Admin. approval of minor changes made to the EPC approved Site Plan to avoid existing utility lines that were not located correctly on the site survey (relocating dumpster enclosure); and to address constructability and durability concerns (minor adjustments to ext. facades).

EPC #20018-001760 / SI-2018-00223; City Council Hearing File # AC-19-2; SI-2019-00308

March 12, 2021

The purpose of this letter is to provide justification for the minor changes that have been made to the Environmental Planning Commission (EPC) approved Site Plan for the Singing Arrow Community Center located at 13200 Wenonah Avenue SE, in the Canada Village – Second Unit Subdivision in response to issues that have arisen during the construction of the project. The relevant project numbers for this project are: EPC Project #20018-001760/SI-2018-00223, City Council Public Hearing File #AC-19-2; and SI-2019-00308.

PARTIAL SITE PLAN

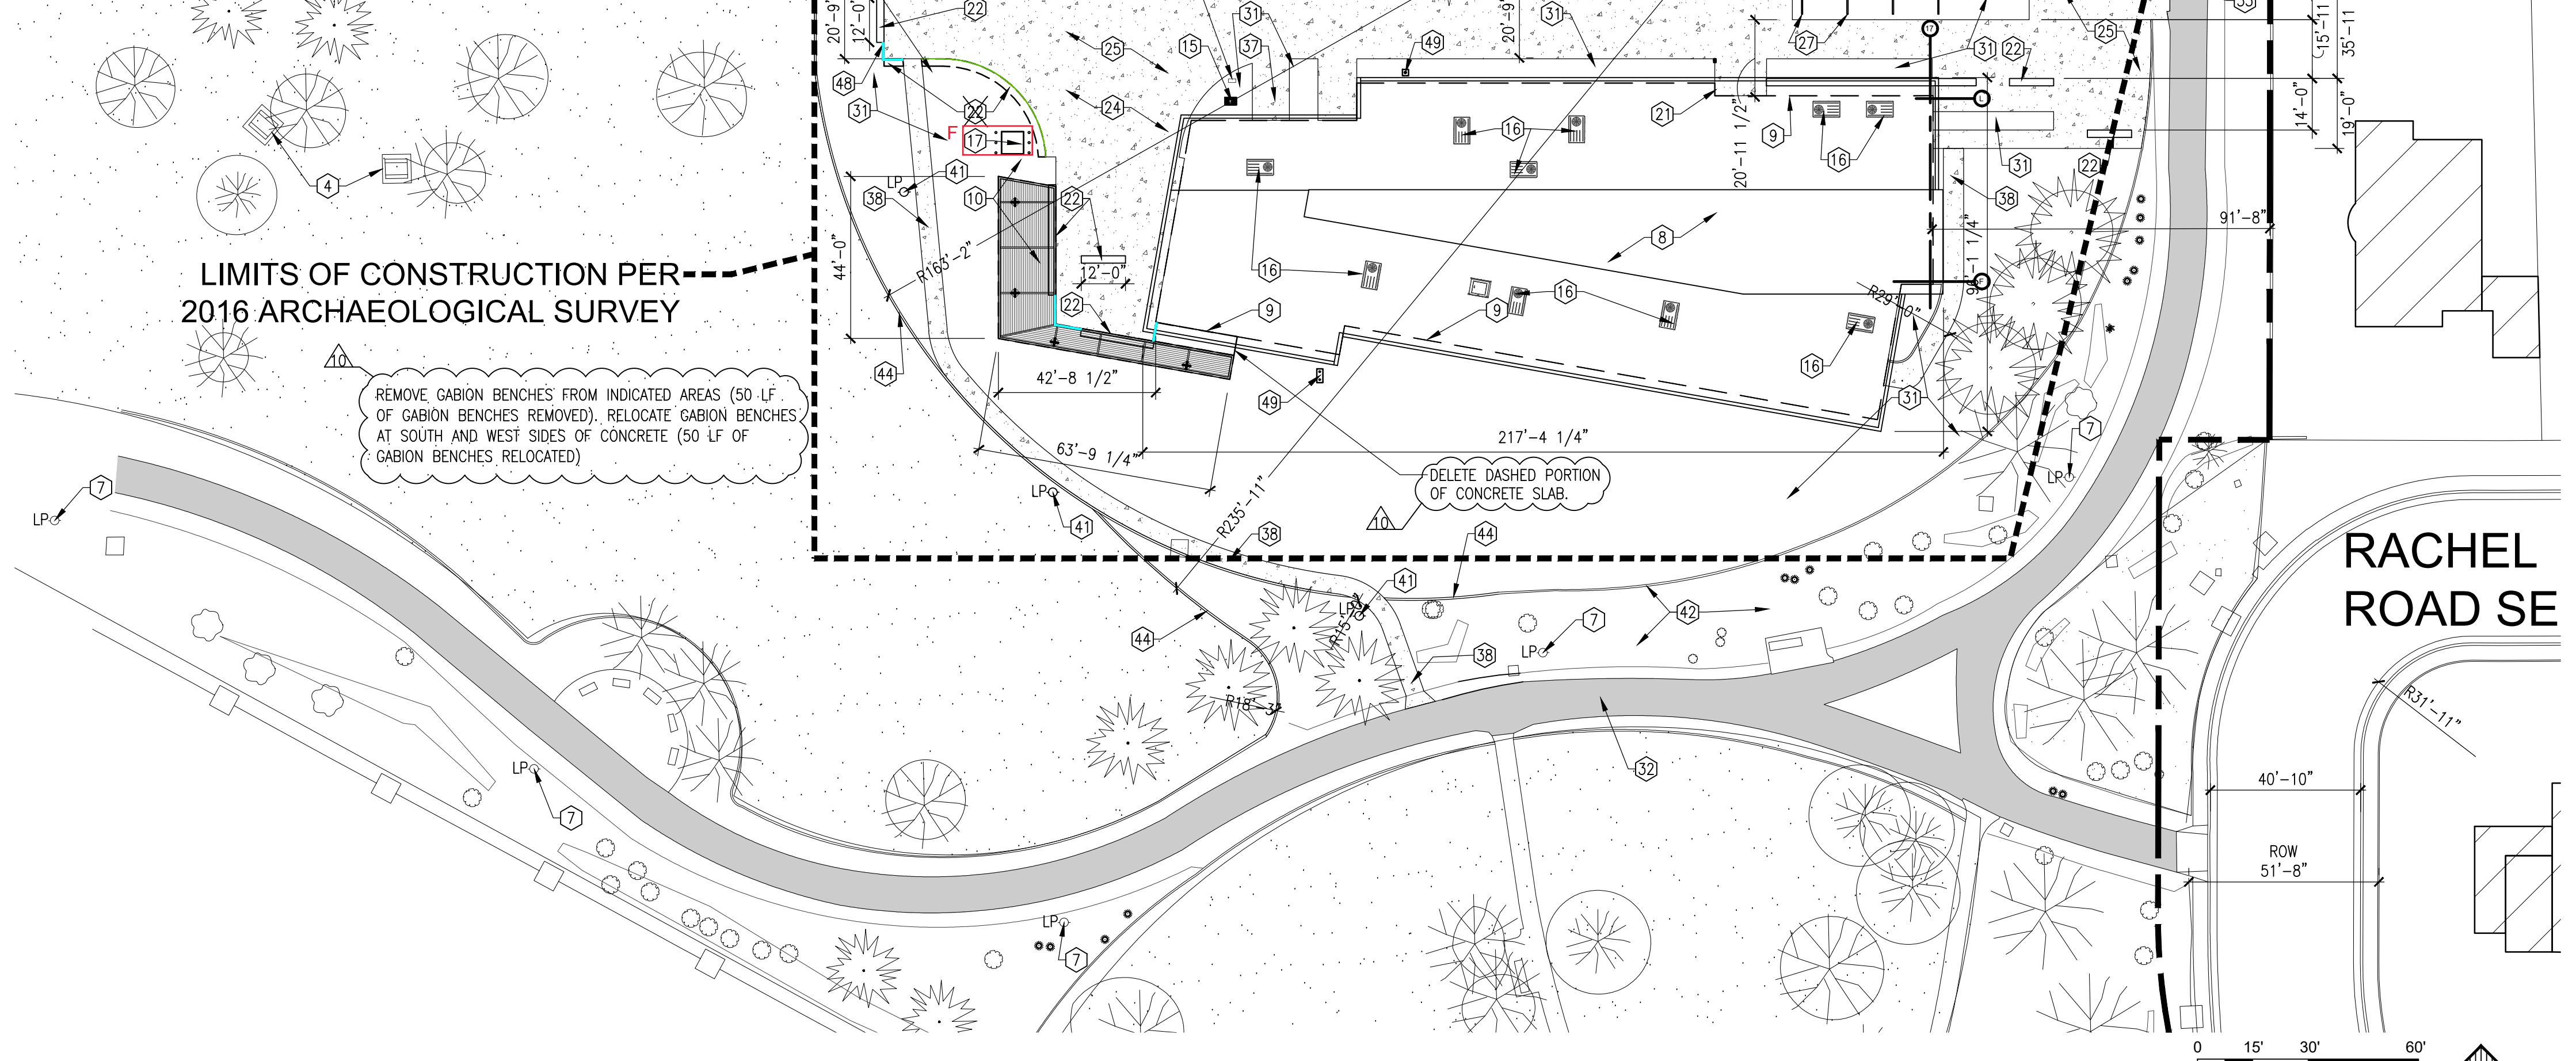
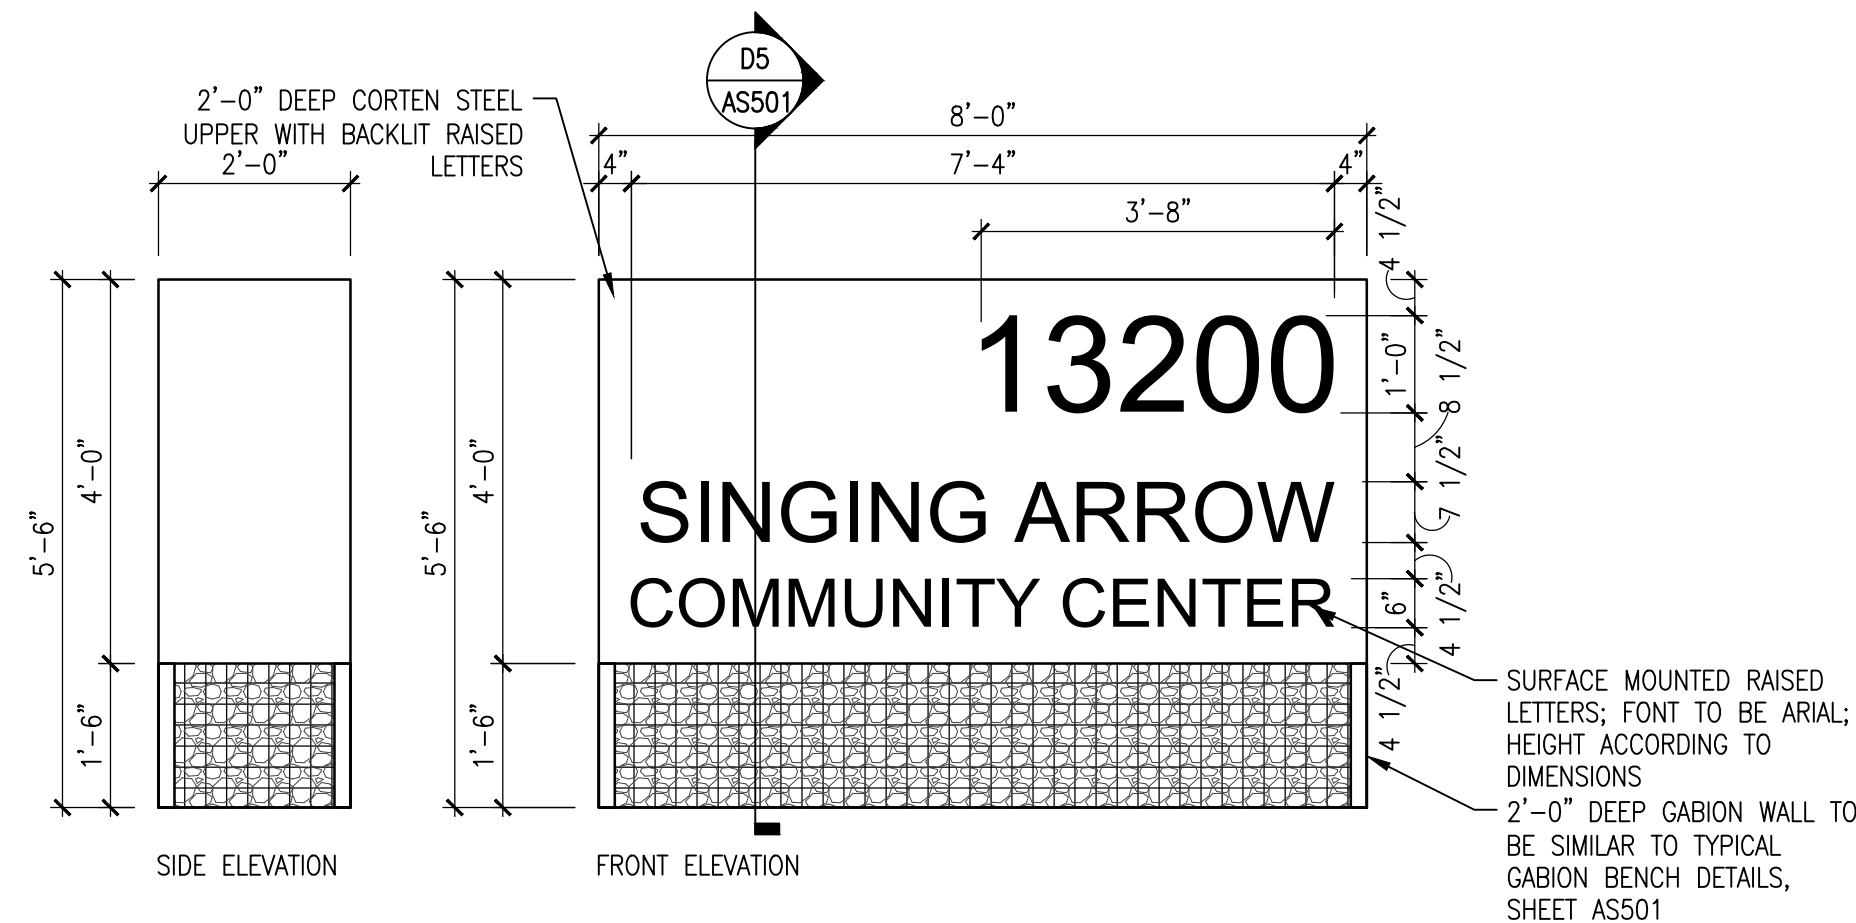
- F. Six bollards were added at the transformer pad to meet PNM requirements. (MCR #010).
- G. The dumpster enclosure was moved from the east edge of the parking lot to the west edge of the parking lot to avoid existing utility lines uncovered at the east edge of the site. An existing water line was shown on the survey approximately 15'-0" away from its actual location in the field. (MCR #020)

- a. Modify curbs, planting areas, and parking spaces to provide proper clearances and access.
  - b. Shift 3 parking spaces north, and shift adjacent graded retention planting area south to provide all required access to the dumpster enclosure. Area of graded retention planter to be the same or equal as that approved in the Site Development Plan.

- c. A total of 2 of 70 parking spaces will be removed to accommodate new location of dumpster enclosure. IDO requirement is for 30 total parking spaces.

- d. At east side of parking lot, modify curb and planter area to smooth out curbs at the old location for the dumpster enclosure.
- H. Update Parking Calculations per changes listed in G.c. above.

- I. Remove two trees that were identified to be retained on the Site Plan to provide required access for all grading equipment to maneuver the site, and clear (ASI #04). Provide two new deodar cedar trees to replace the two removed trees (ASI #09). Total number of trees included on the approved Site Plan will be the same.

- J. At west end of the building and at the north fire lane, modify the curb details and gabion bench locations. Remove small portion (approximately 115 sf) of concrete at southwest end of building. (ASI #08).

- a. Relocate gabion benches on west side of site to be located under shade structure, and to provide improved edge condition at concrete drive pad. Total quantity of gabions provided is unchanged.

- K. Make minor modification to layout of concrete walkway outside of door 121B on east side of building to meet all ADA accessibility requirements (ASI #29). Total amount of concrete is approximately 10 sf more than what is included on the approved Site Plan.

- b. F. All curbs in parking lot to be curb and gutter. See detail E4/AS502.
- M. Add detail C1/AS102, 15 in Drain Basin Quick Spec Installation Detail. Detail was added by Civil Engineer by Addendum during the bidding of this project to provide additional information for the Contractor.
